From: alan.story@hertfordshire.gov.uk
Sent: 26 June 2015 09:53
To: Planning
Subject: Planning application S6/2015/1034/FP - 31 Salisbury Square

Response to Planning application from Hertfordshire County Council (T and CP GDP Order 2015)

District ref: S6/2015/1034/FP

Change of use from existing offices (B1) to six residential dwellings (C3), extension and conversion of existing loft space to one dwelling and erection of new block in existing car park to provide th

Site & Ground Floor Plan scale 1:100

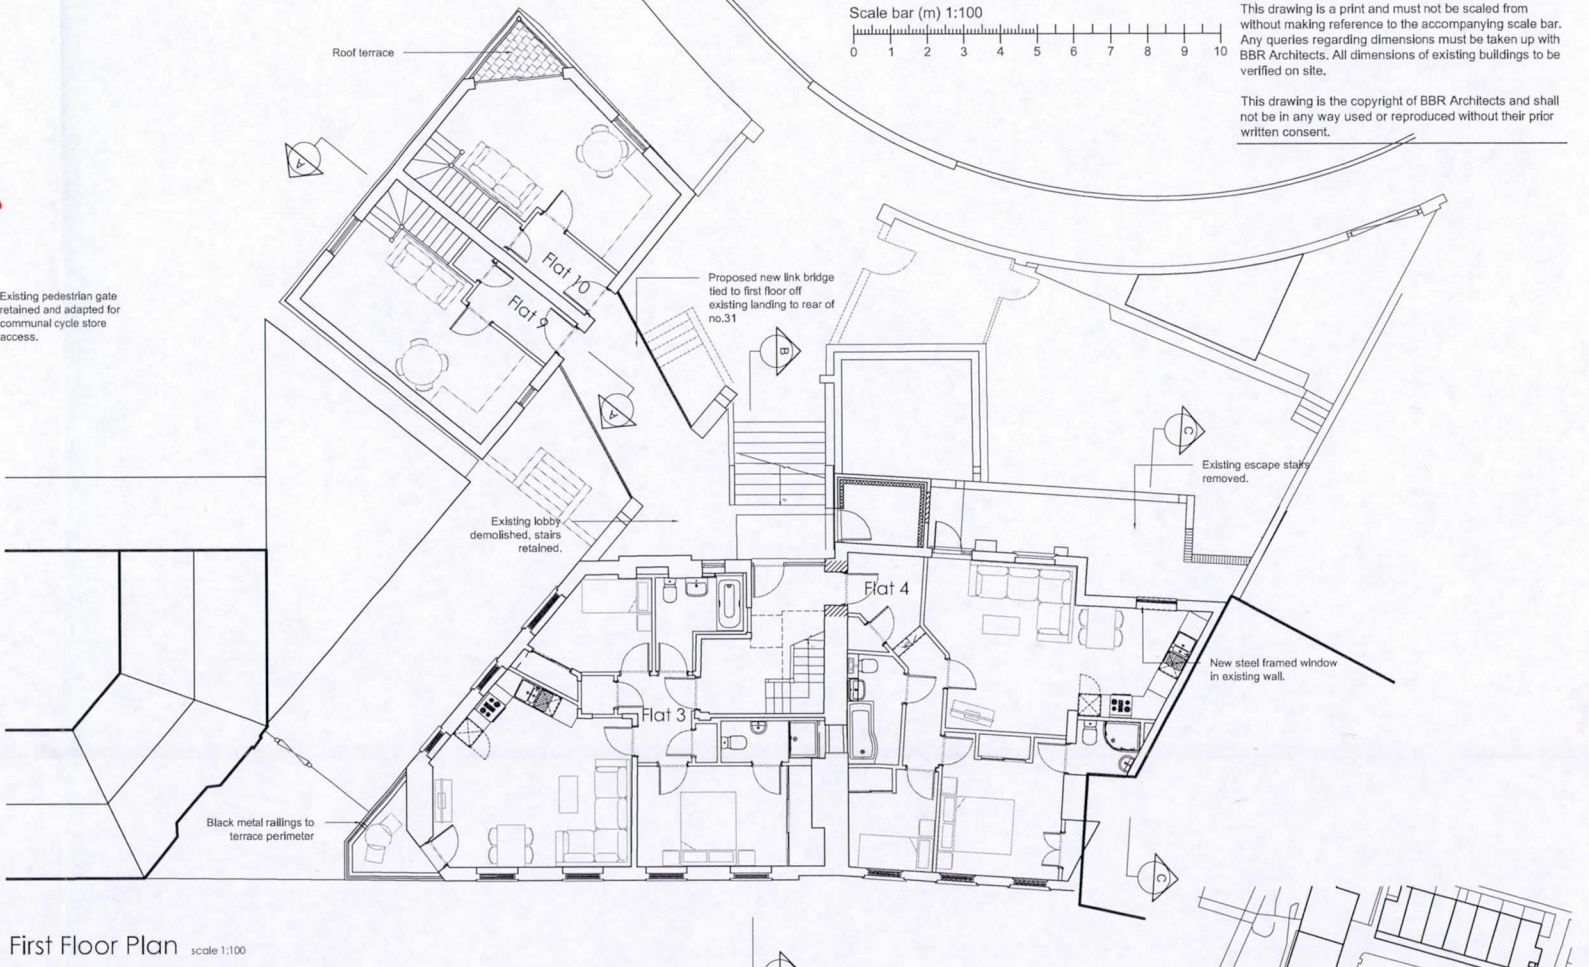
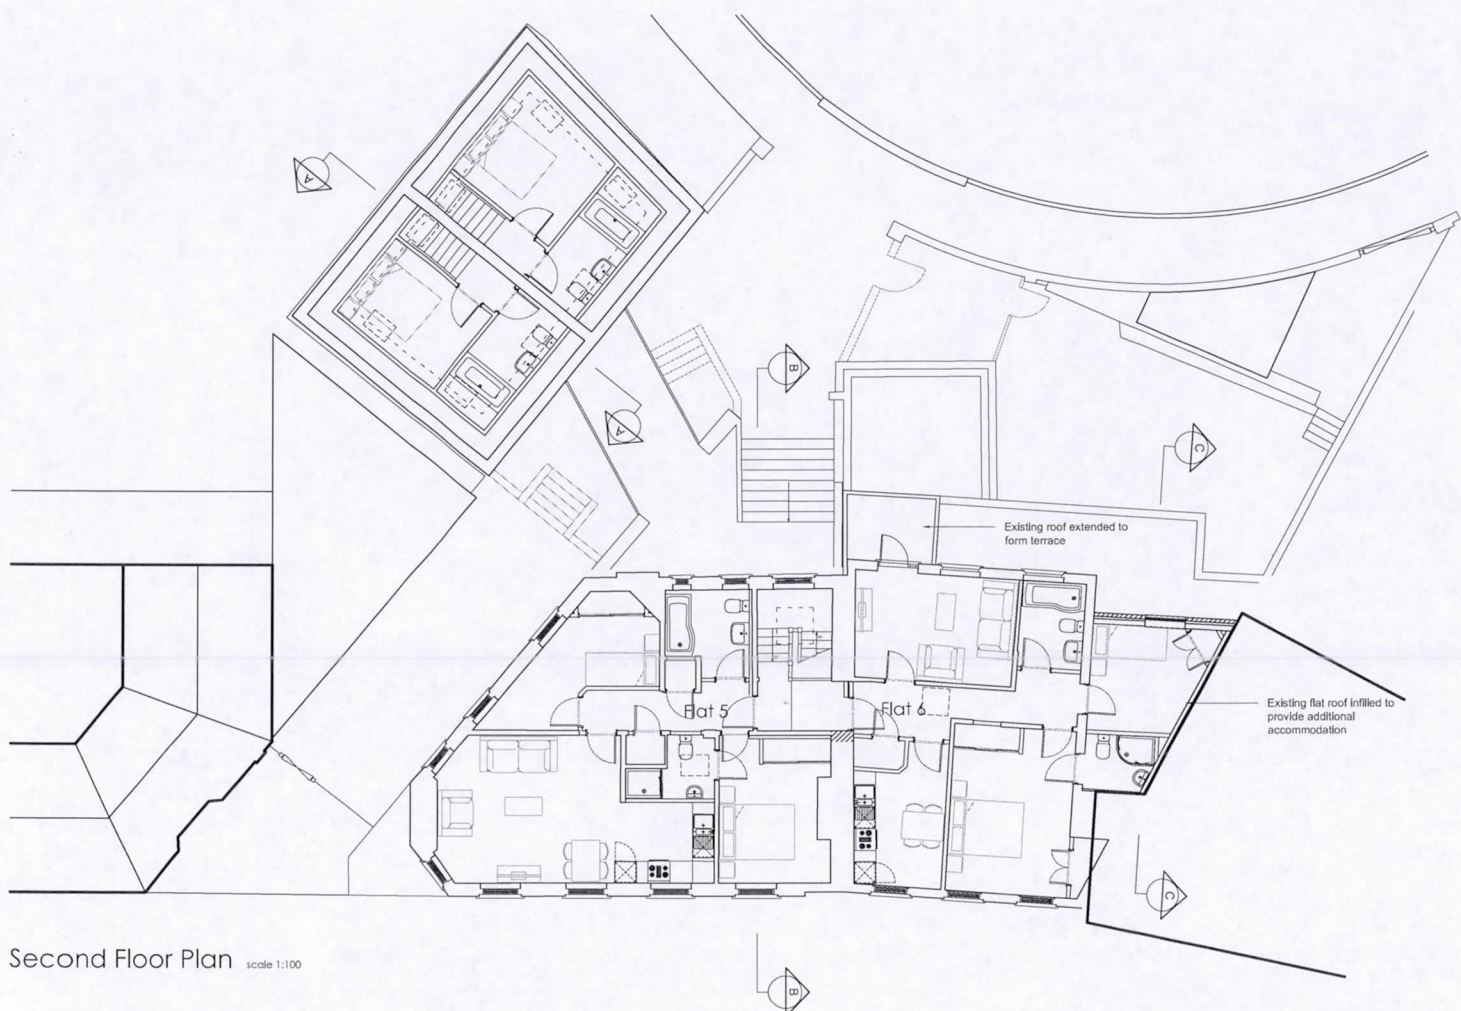
In addition to the loss of car parking, the proposals include the provision of a link bridge structure between the existing building and the proposed new structure, tied in to the existing building at 1st floor. The provision of steps to this bridge serve to further restrict vehicle movement within the site, however no detail in respect of entry treatment is provided, particularly to Battersdale i.e. whether the site shall be restricted to pedestrians only.

Without appropriate entry treatment there shall be a potential for vehicles to enter the site, at a point with limited visibility and given the absence of parking for the development as a whole, give rise to conflict over vehicles competing for the potential one (1) space provided in the site.

Details on pedestrian only gate, or other entry treatment, is sought.

In such an event, HCC would expect that any vehicle crossover not necessary to facilitate vehicle access to the site be reinstated, with the footway returned to the same line, level and construction as the adjacent footway

I would seek confirmation that the cycle store is provided by use of the existing northerly most gate to Battersdale. If this gate is permanently stopped up, use of the store shall require bikes to be transferred through the bin store, providing an unpleasant route and not supportive of encouraging the use of bicycles as an alternative to private car use / ownership.
